Historic Preservation Certification Application
State Historic Preservation Office Review & Recommendation Sheet
Significance - Part 1

Number 1	George S. Hunt Block (Property) 660 Congress Street, Portland, ME
Congress Street Historic District and Spring Street Historic District (Historic District)

CONDITIONS SHEET
Historic Preservation Certification Application

PROPERTY: George S. Hunt Block, 660-662 Congress Street, Portland, ME
PROJECT NUMBER: 28761
APPLICATION: Part 2 Amendment
DECISION: Approval

DWG. NO.: **A-603**

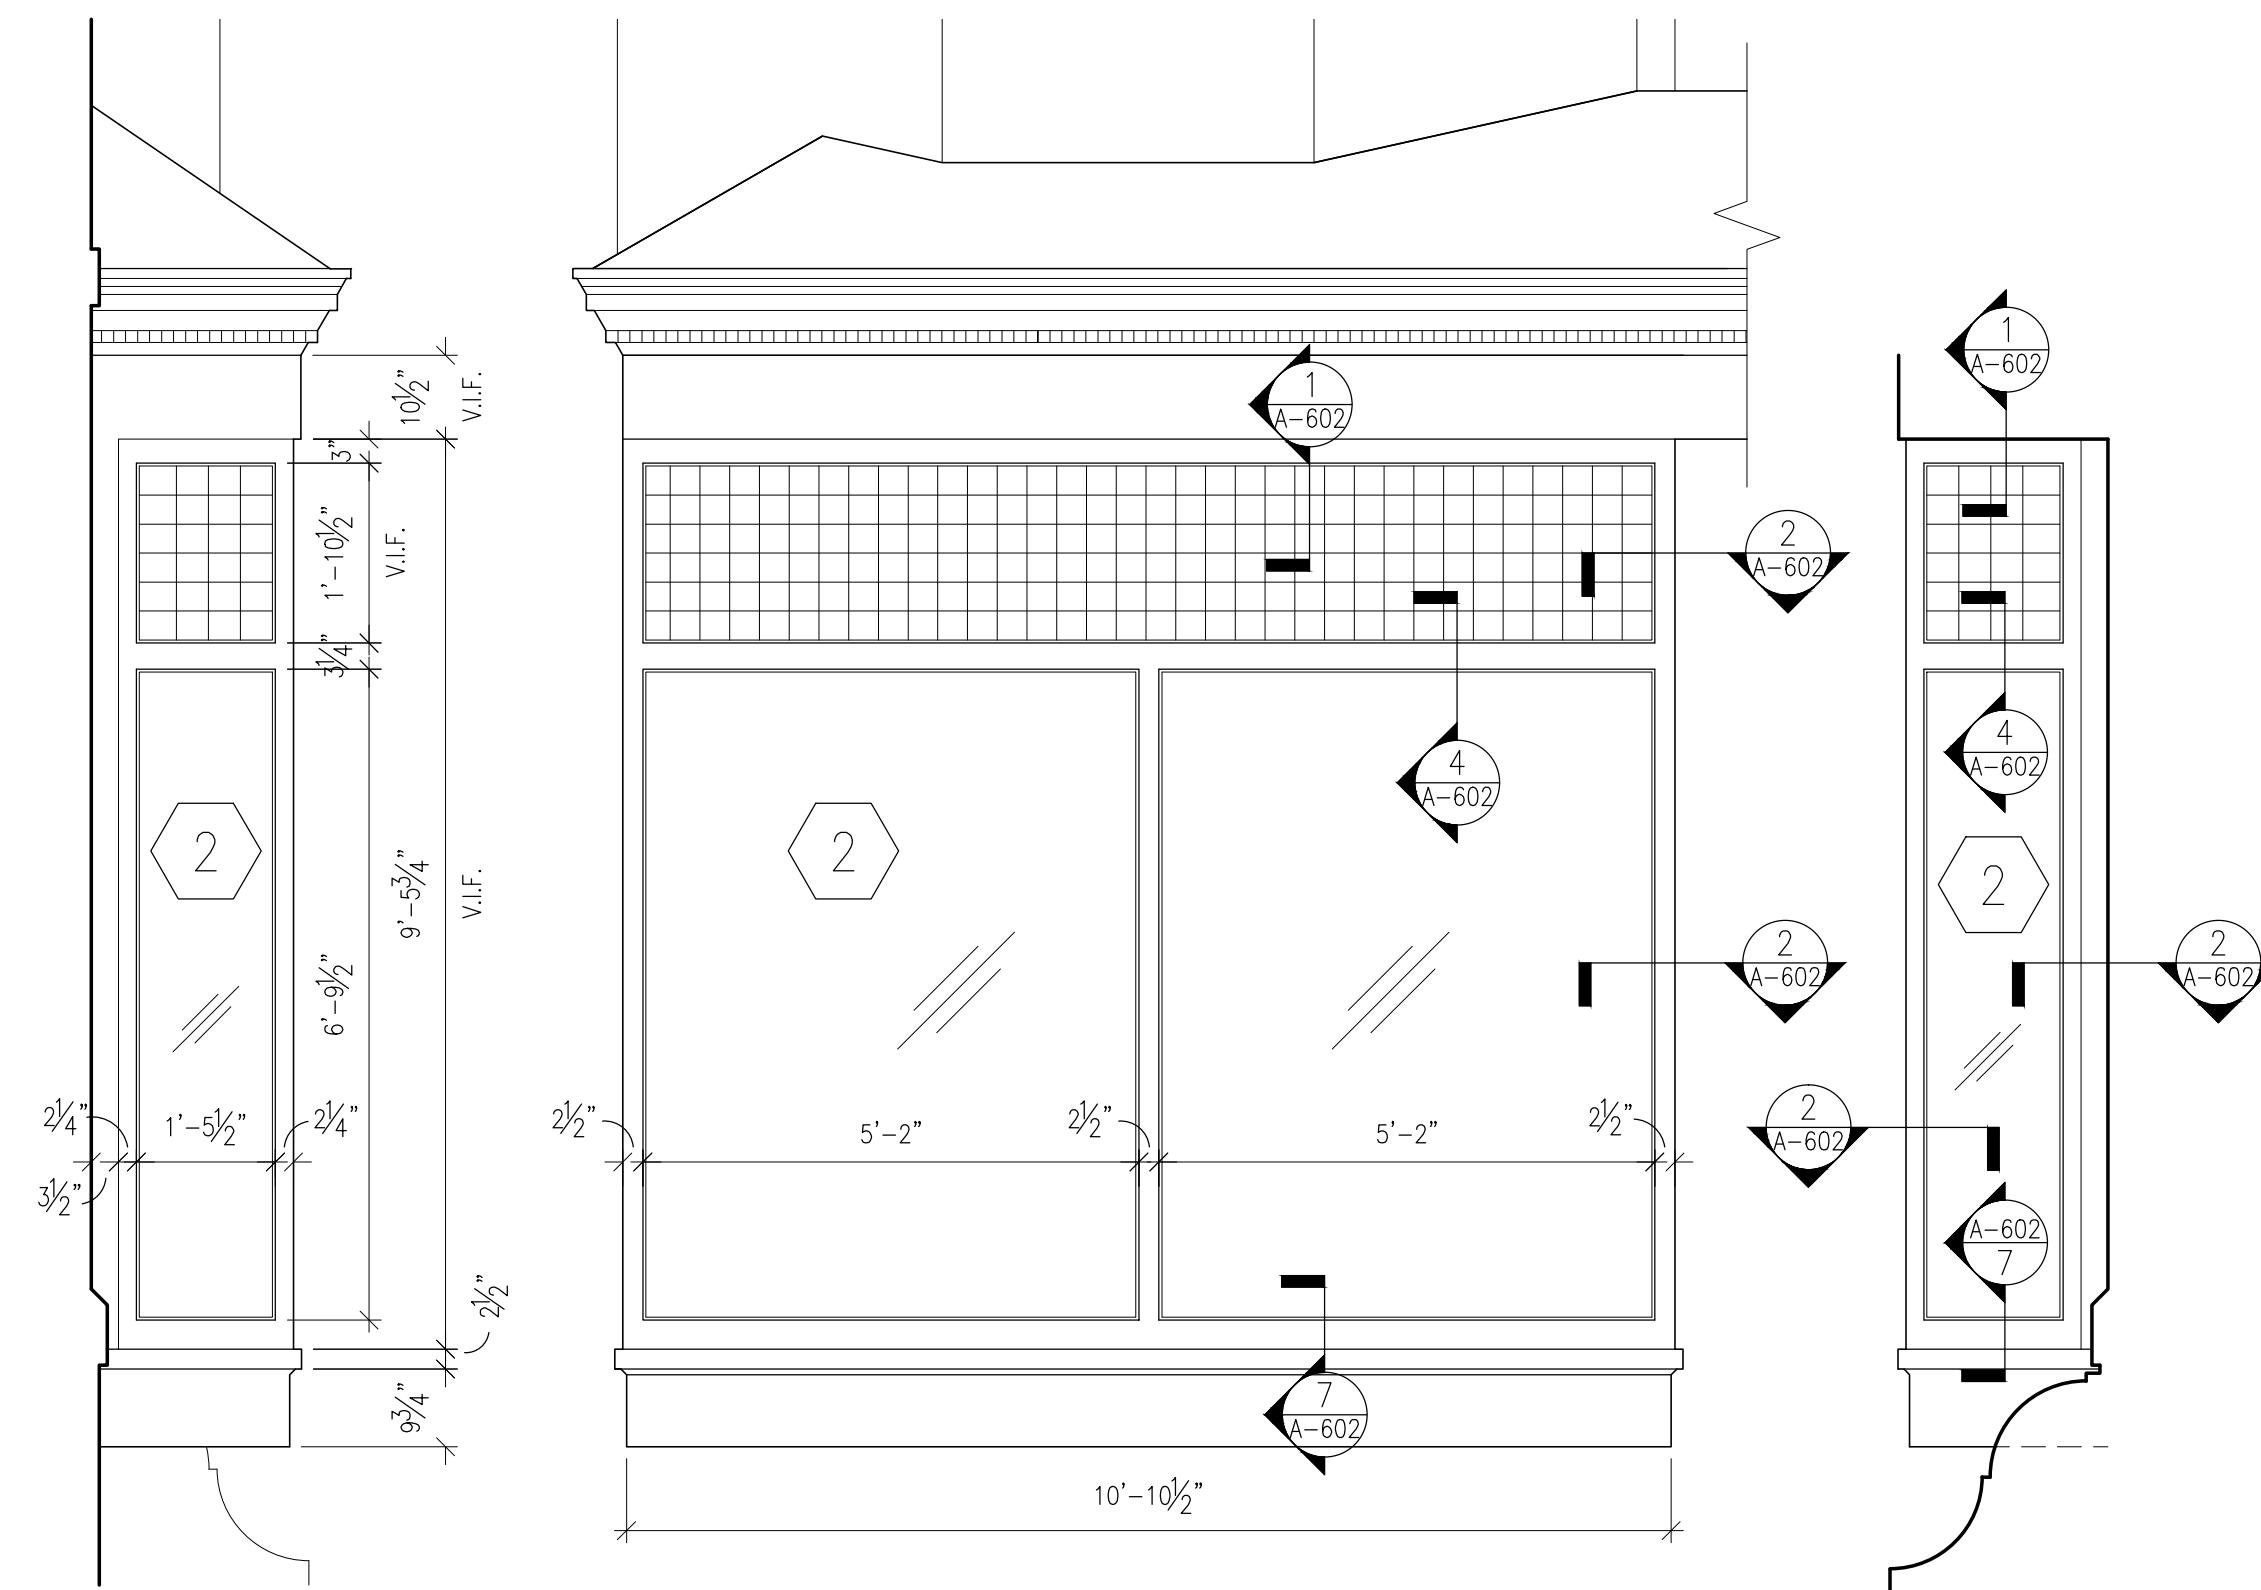
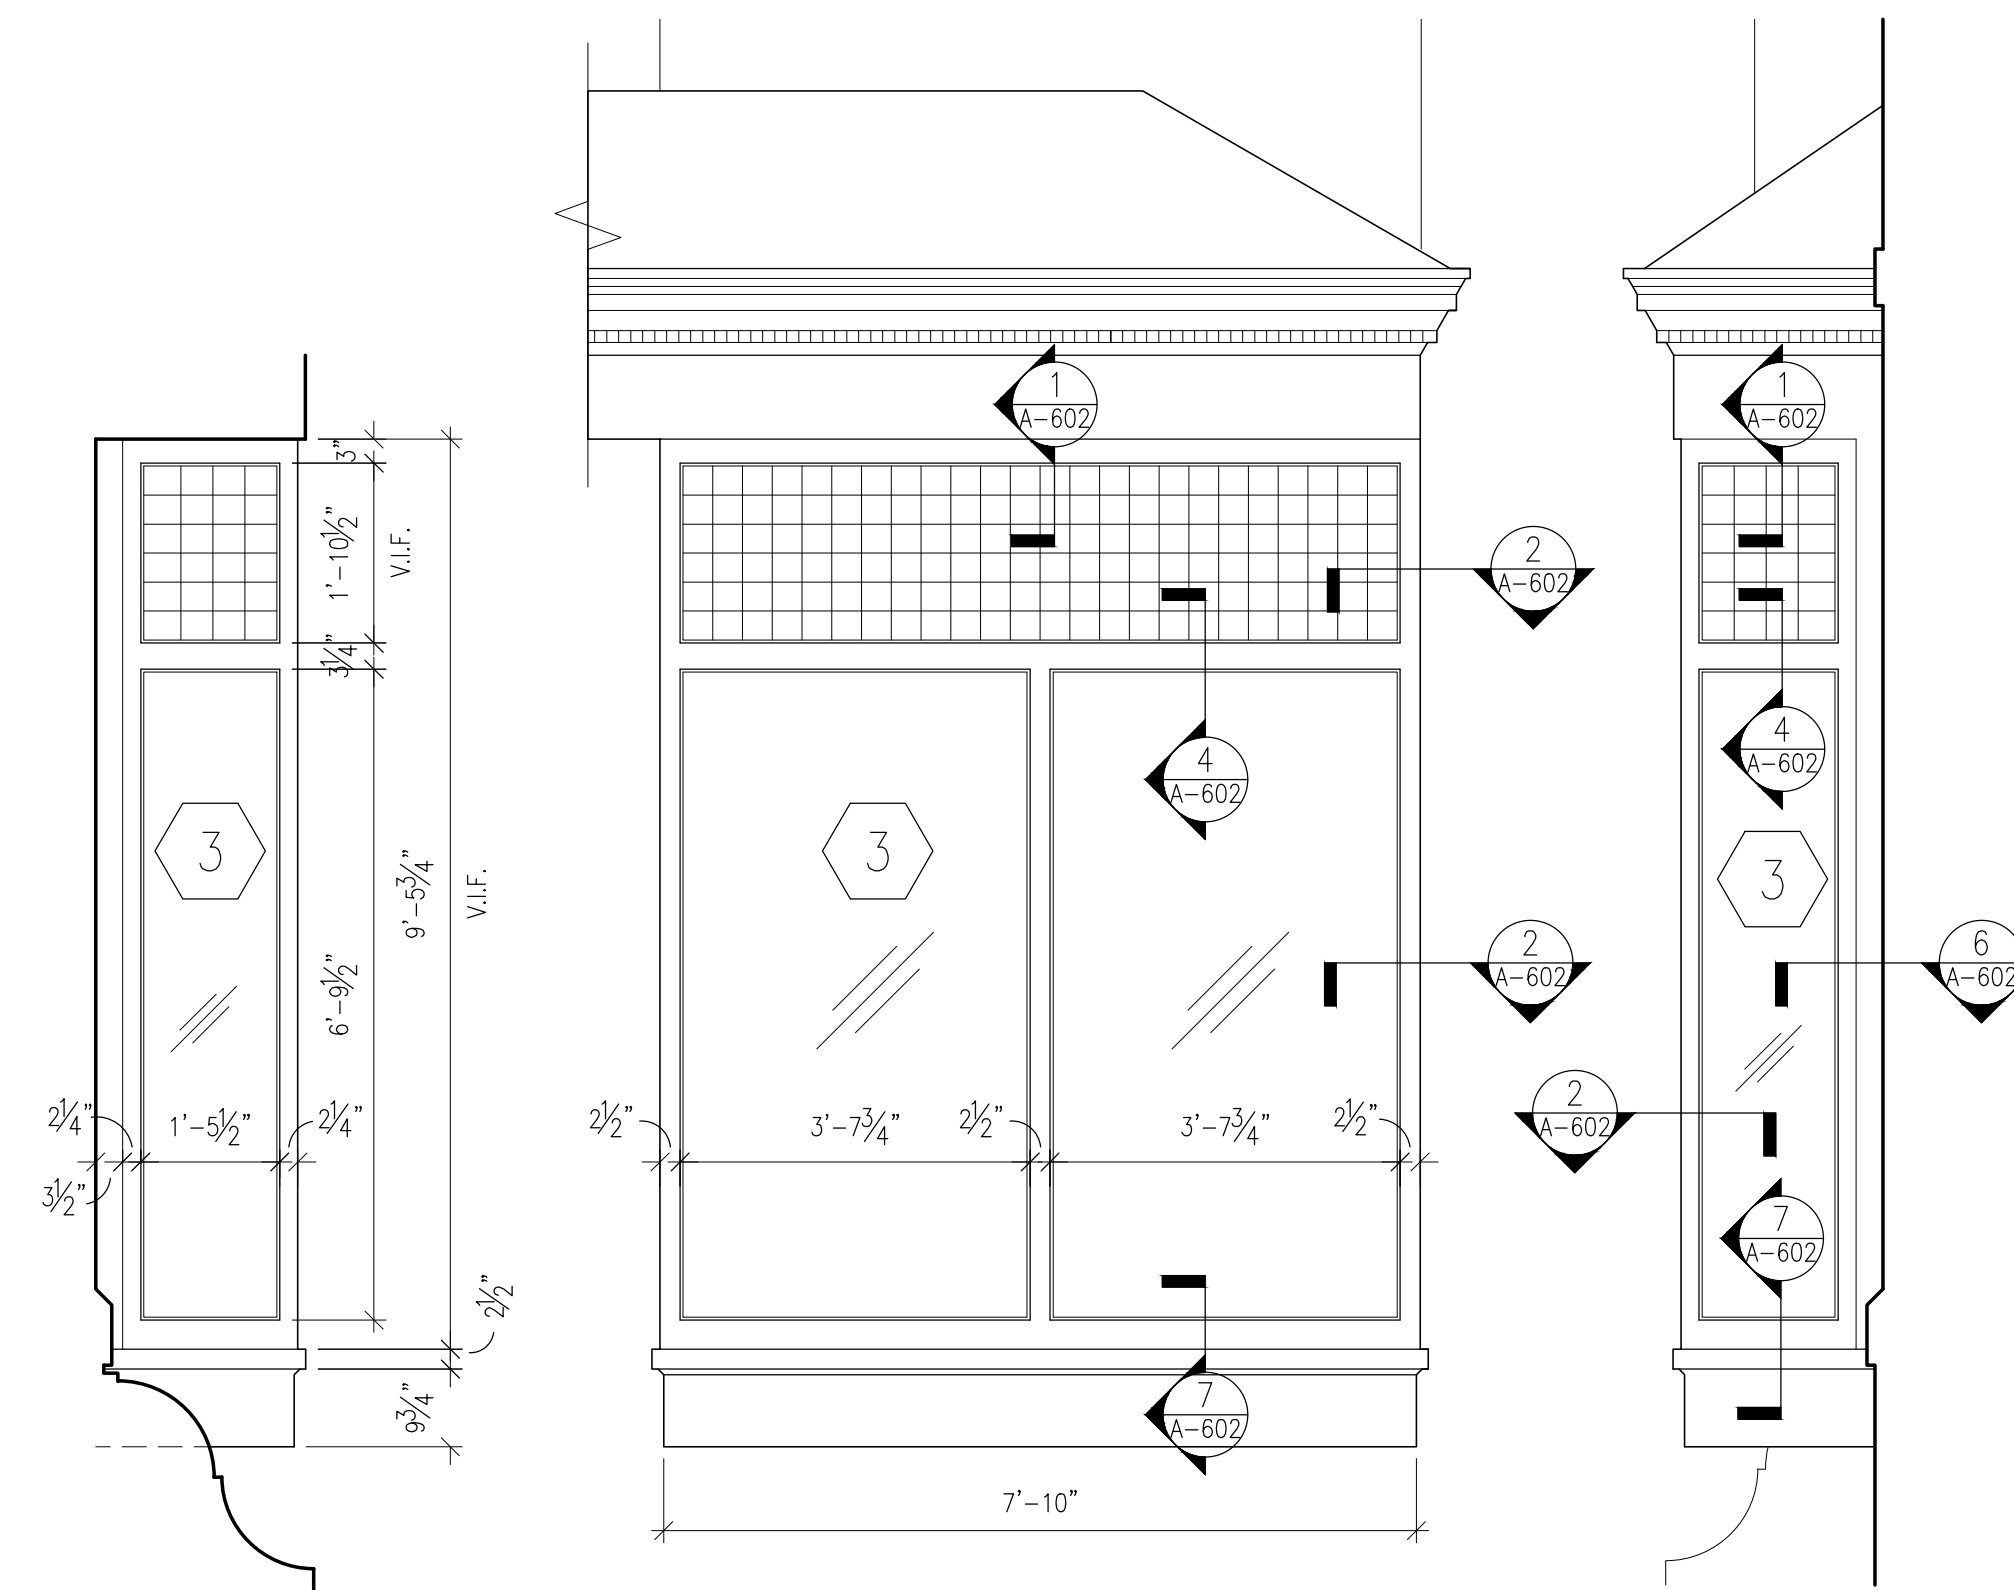
Storefront Windows – The replacement first floor commercial bay window located on the eastern side of the Congress Street elevation must match the configuration of the existing multi-light window designed by John Howard Stevens. This 1950 window was constructed during the period of significance for the Congress Street Historic District and has gained significance in its own right. The proposed window is not based on any historical documentation and is not compatible with the proportions of the façade.

The National Park Service has reviewed the additional information received on August 27, 2013 for the above-referenced Historic Preservation Certification Application for this project. After careful consideration, we have determined that the revised storefront proposal is in conformance with the Secretary of the Interior's Standards for Rehabilitation and with the preliminary approval issued by this office on May 29, 2013.
